7 September 2022

EPA Advice on Submissions Report

Thank you for the request for advice from the NSW Environment Protection Authority (EPA) in relation to the Response to Submissions for the proposed Rooty Hill Materials Recycling Facility (SSD-29999239) (the Proposal) at Lot 67 DP804292, known as 600 Woodstock Avenue, Rooty Hill NSW 2766 (the Premises).

The EPA has reviewed the *Materials Recycling Facility, 600 Woodstock Avenue, Rooty Hill Response to Submissions – SSDA-29999239* prepared by Urbis Pty Ltd and dated 10 August 2022 (the RTS) and the associated documents.

Figure 4 Kerbside receival bays

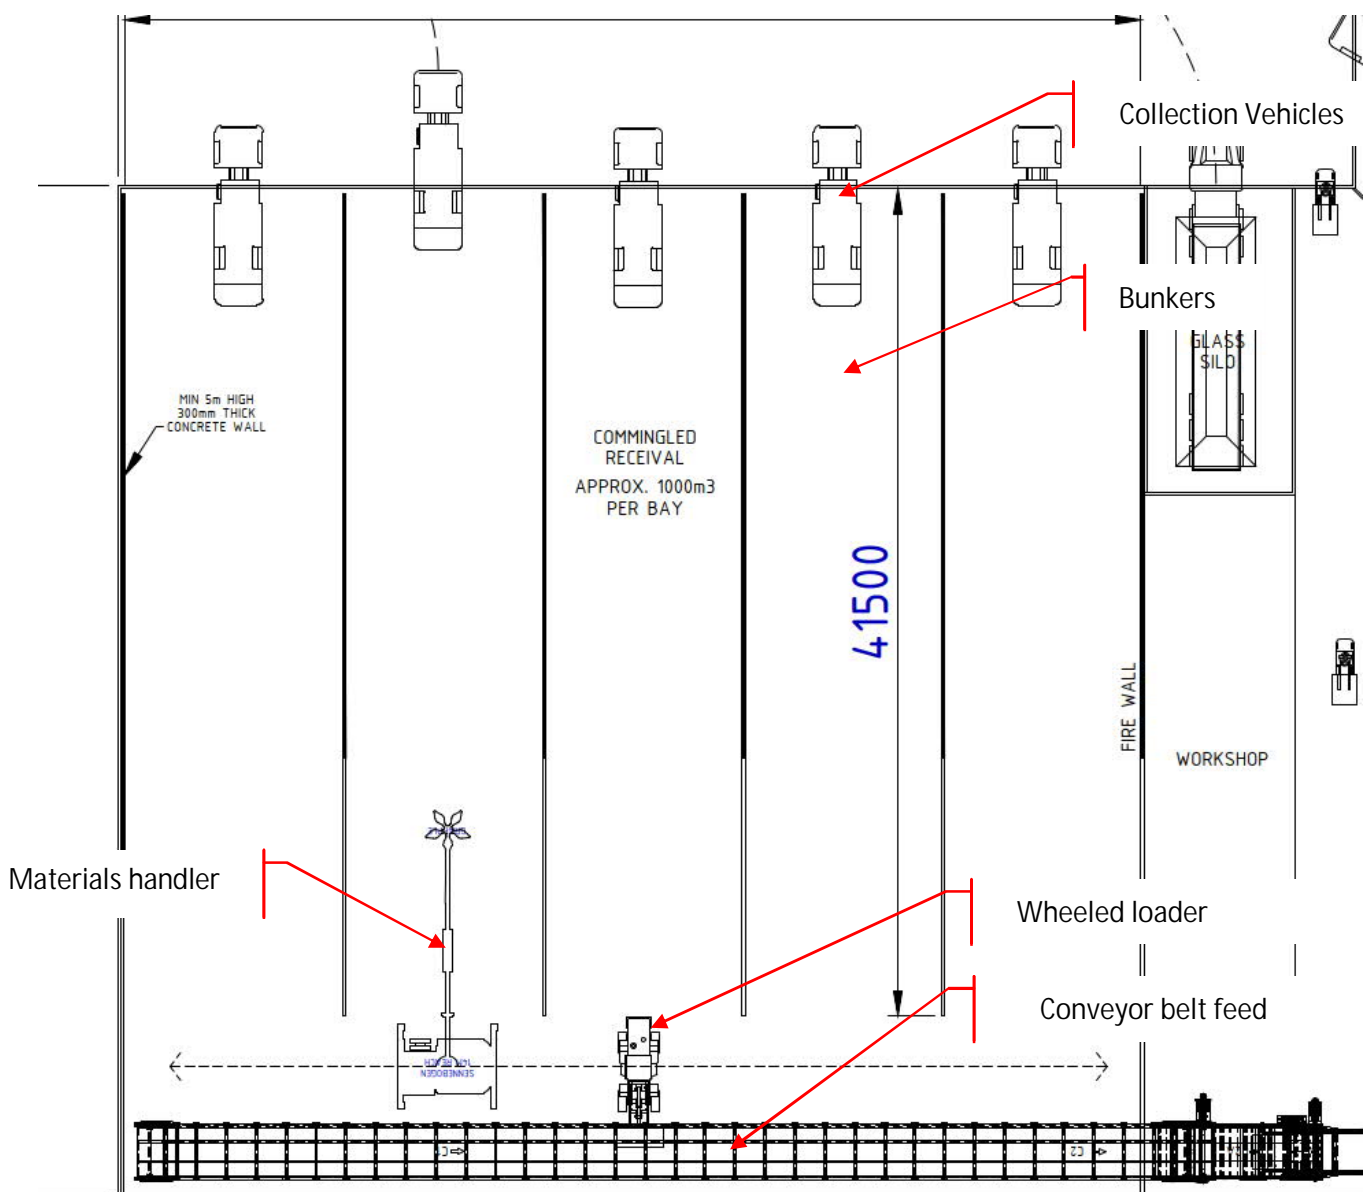
The EPA is concerned that it appears loads of waste will only be inspected following the departure of the truck which was carrying that load. This prevents the rejection and re-loading of non-conforming waste so that it can be immediately removed from the Premises which is the best practice method for managing non-conforming waste and preventing potential environmental impacts from that waste at the Premises.

The RTS and WMP advise there will be an interim storage location for non-conforming wastes which will be used as quarantine which is not sufficient. There must be a permanent quarantine location at the Premises which is solely used for this purpose.

- i) Detailed information must be provided regarding the management of non-conforming waste including general solid waste (putrescible), contaminated waste, and hazardous waste. Methods for the detection and removal of non-conforming waste must be clearly set out. Management methods must be provided with reference to the stage at which any non-conforming waste is identified and with consideration of best practice.*
- ii) A permanent and dedicated quarantine area must be in place at the Premises. The quarantine area must be used solely for this purpose and be suitable for the storage of hazardous or contaminated waste.*
